A103 Memorandum

Date:	11 th July 2019			
Project Name:	Newcastle Courthouse Redevelopment Nihon University			
Project No:	auncl-17-0347			
Reference:	17-0347 memo 25 – 11.07.2019			
Page	1 of 5			
To:	Copy	Company	Attention	Circulation
✓		NSW Department of Planning & Environment	Megan Fu	Megan.Fu@planning.nsw.gov.au
	✓	City Plan	Murray Blackburn-Smith	murraybs@cityplan.com.au
	✓	Azusa Sekkei Co Ltd	Jun Yokobori	yokobori1482@azusasekkei.co.jp
	✓	dwp Australia Pty Ltd	Ed Clode	edward.c@dwp.com
	✓	dwp Australia Pty Ltd	Katherine Daunt	Katherine.d@dwp.com

25 SSD-9787 Nihon University Newcastle Campus – Waste Management Response

2. On-site Waste Storage Facilities

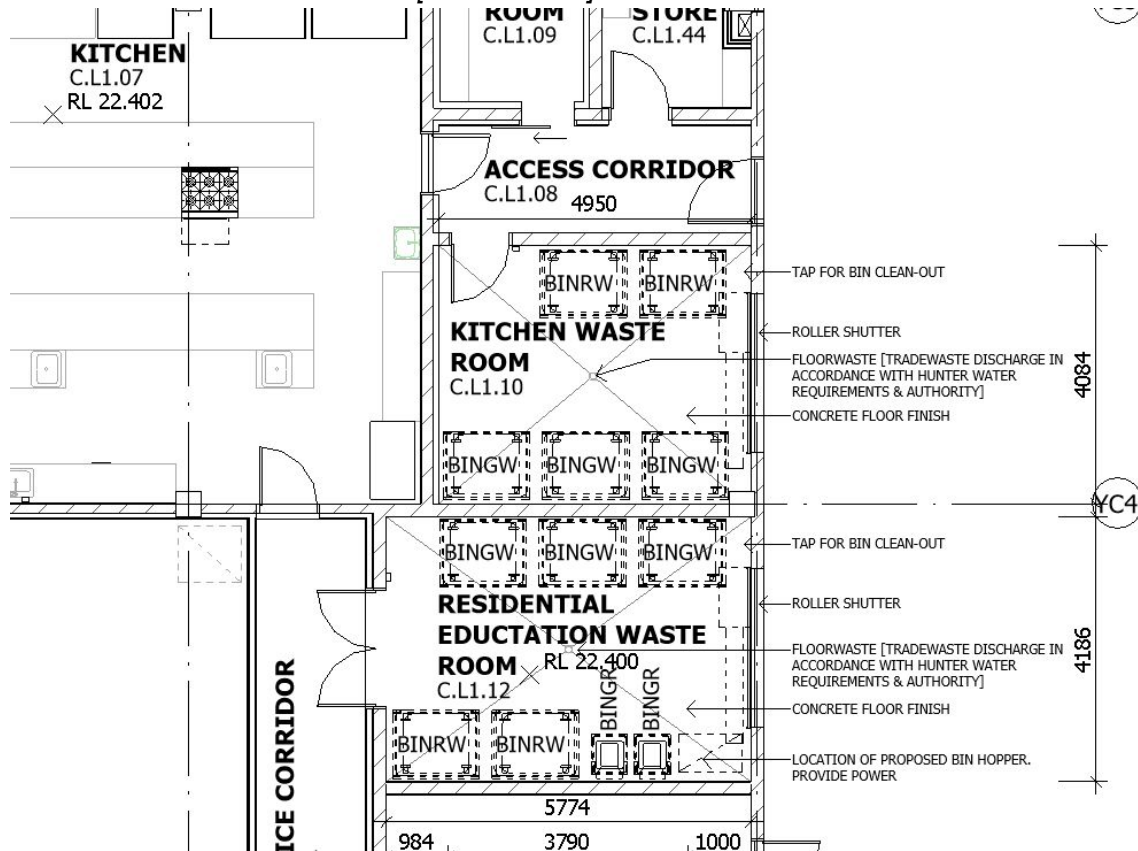
The design of the two waste bin storage rooms is:

- To be large enough to accommodate the entire fleet of bins plus 0.2m between bins to allow adequate maneuverability space.
- To provide a 1.8m unobstructed clearance zone between the stored bins and the entrance to permit access and maneuverability.
- To provide suitable dual door access for the service of bins with a minimum width of 1.8m and accessed by a 1.8m unobstructed access corridor.
- To be located within proximity to the on-site loading bay.
- To be fully enclosed, walled and not permit through access to other on-site waste infrastructure. Separate unobstructed access is required.

25.02 Design of Waste Storage Rooms

The design of each of the Waste Storage rooms have been amended as follows:

- Increased room sizes to accommodate increased fleet of bins:
 - Cafeteria & Kitchen Garbage Room size = 4.7mL x 4.1W approx,
 3 x Garbage Waste 1100L MGBs
 2 x Recycling Waste 1100L MGBs;
 - Residential & Education Waste Room size = 5.8mL x 4.1W approx,
 3 x Garbage Waste 1100L MGBs
 2 x Recycling Waste 1100L MGBs
 2 x Organic Waste 240L Mobile Wheelie Bins;
- Bin size to remain as typical 1100L MGB sizes: 1373w x 1073d x 1354h (equal to Otto);
- A clear 1800mm unobstructed zone between the stored bins to permit access and manoeuvrability;
- A minimum of 200mm between MGB bins to permit access and manoeuvrability;
- Each waste storage room co-located, with easy access to the adjacent hardstand to access the street;
- Each room is fully enclosed and walled, and does not permit access to other areas of the building.
